Charlotte Department of Transportation

Memorandum

Date: March 26, 2008

Subject: Rezoning Petition 08-070: Located in the block bounded by North Davidson Street, East 26th Street, East 27th Street & Yadkin Avenue

DATE: January 3, 2008  
 DESIGNED BY: CCM  
 DRAWN BY: SK  
 CHECKED BY: CCM  
 SCALE: 1" = 40'  
 PROJECT #: 1007324  
 SHEET #:  
**RZ-1.0**

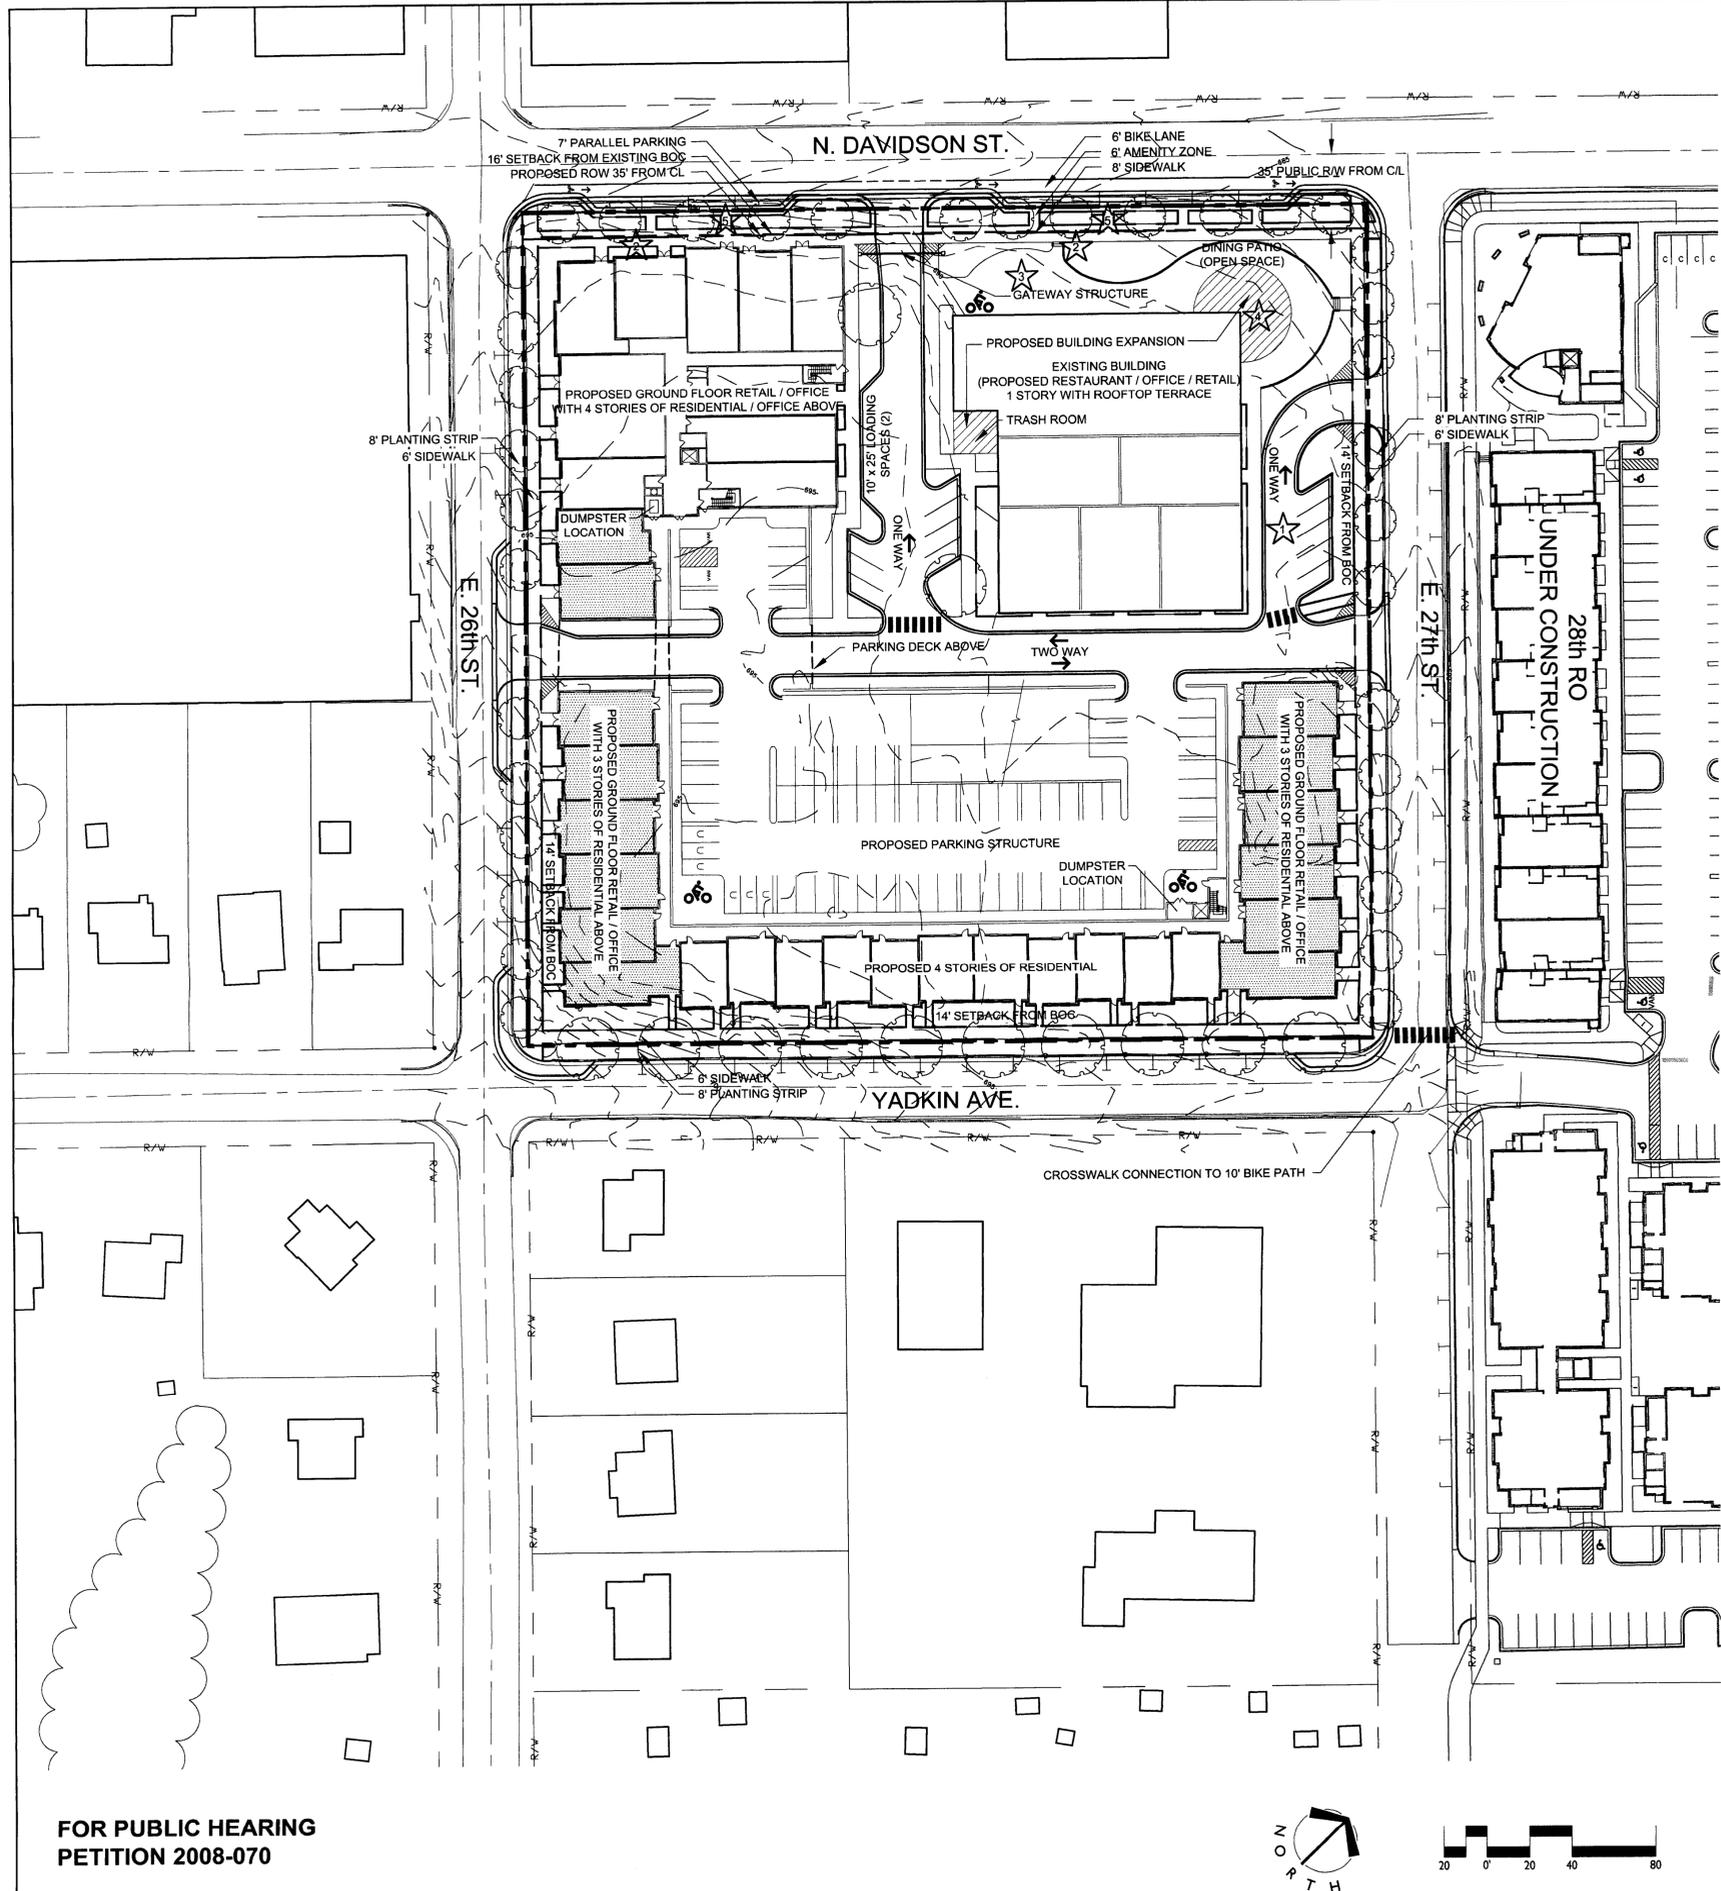
1. The developer does not need to modify the curb along North Davidson Street, because CDOT has determined that on-street parking should not be provided at this time. As the area continues to redevelop, CDOT will re-evaluate on-street parking in the future for this section of North Davidson. If it can be supported at that time, there appears to be sufficient width between the existing curblines to accommodate on-street parking. Without recessed parking

along North Davidson Street, the 14-foot setback per MUDD zoning may be located closer to the existing curb, instead of measured from recessed curbs.

2. The developer needs to construct curb extensions at intersections and access points along both East 26th Street and Yadkin Avenue to physically separate the proposed on-street parking from the travel lanes.

3. Existing back-of-curb sidewalks need to be replaced with an 8-foot planting strip and 6-foot sidewalks (required by UR zoning), as measured from a new curb line at least 5 feet out from its current location.

4. The proposed access point on North Davidson Street will not be approved because reasonable access can be provided on both E. 26th and E. 27th Streets.

5. If the parking structure is to have controlled entry, the locations of the gates need to be included in the plans and be located a minimum of 20 feet from the setback line.

6. Dumpster/trash collection locations need to be shown on the site plan as well as the accessing/maneuvering paths for waste collection vehicles to ensure that there is not a conflict with required parking spaces/aisles and that these activities do not require maneuvering/backing into the setback or right-of-way.

7. Development Note 1 under "Access Points" needs to be modified to remove the last statement, "Additional access points may be allowed as needed and are subject to CDOT approval." The number and general locations of access points will be limited to those included and supported by CDOT on the conditional site plan.

1. The planned North Davidson bicycle/pedestrian connection to Pickney needs to be included in this plan.

North Davidson Street is a minor thoroughfare inside Route 4 requiring a minimum of 60 feet of right-of-way. The developer/petitioner should convey right-of-way in fee simple title to meet this requirement, measuring 30 feet from the centerline of the roadway.

Adequate sight triangles must be reserved at the existing/proposed street entrance(s). Two 35-foot x 35-foot sight triangles are required for the entrance(s) to meet requirements. All proposed trees, berms, walls, fences, and/or identification signs must not interfere with sight distance at the entrance(s). Such items should be identified on the site plan.

- Dimension width of the existing and proposed driveways.
- New/reconstructed driveways must be drop curb ramp Type II-Modified driveways.
- Indicate the locations and widths of all adjacent and opposing driveways.
- Indicate typical parking module dimensions.
- Directional wheelchair ramps (two per corner) should be provided at all intersections of public and private streets.
